27 January 2017

**Submission regarding Global Switch Data Centre (MP 08_0222 MOD 7)
Modification Application under Section 75W of the EP&A Act 1979**

Figure 2 Acoustic context of the approved development (Source: Acoustic Logic)

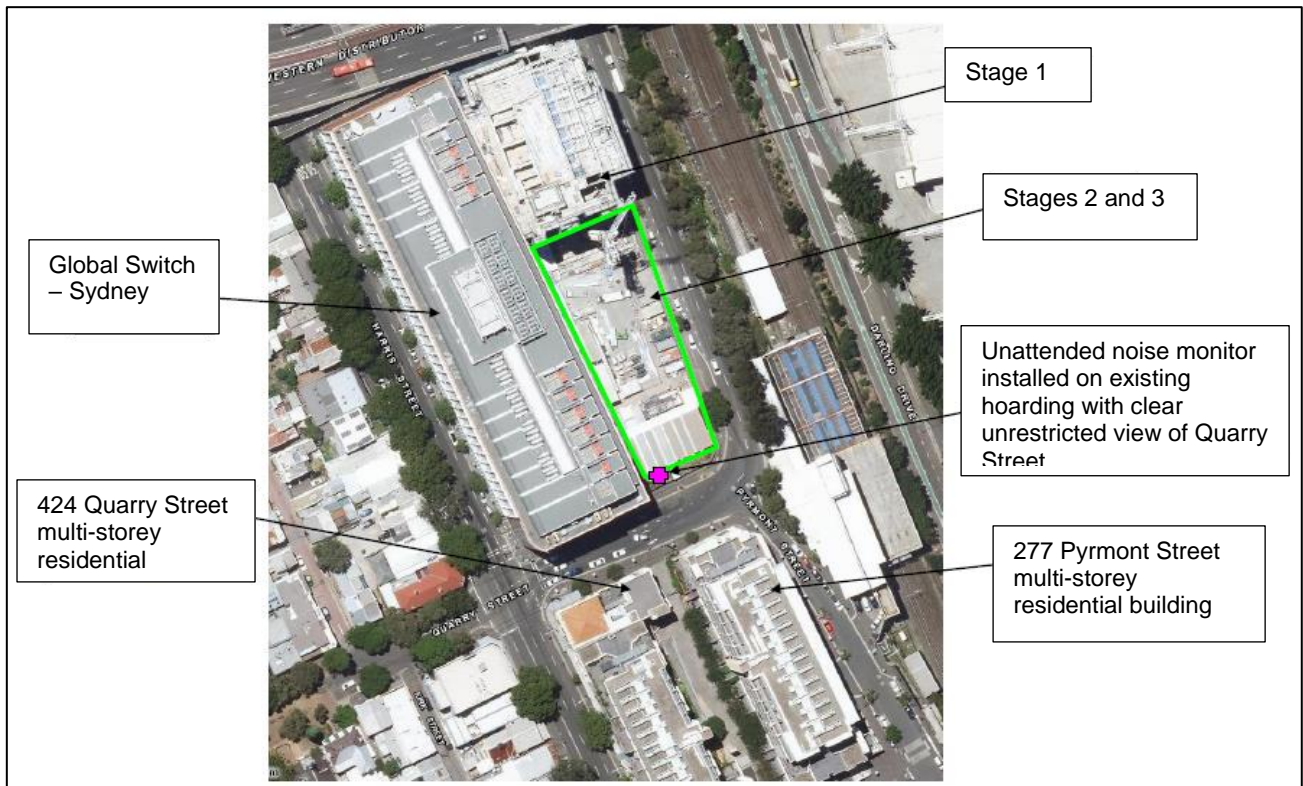
I believe the submission made by Helen Mulcahy¹ incorrectly identifies the multi-storey residential buildings. I refer to an aerial photo on page 9² where the Quarry Building is shown as “424 Quarry Street” and the Pymont Building is shown as “277 Pymont Street”. This aerial photo is attributed to Acoustic Logic.
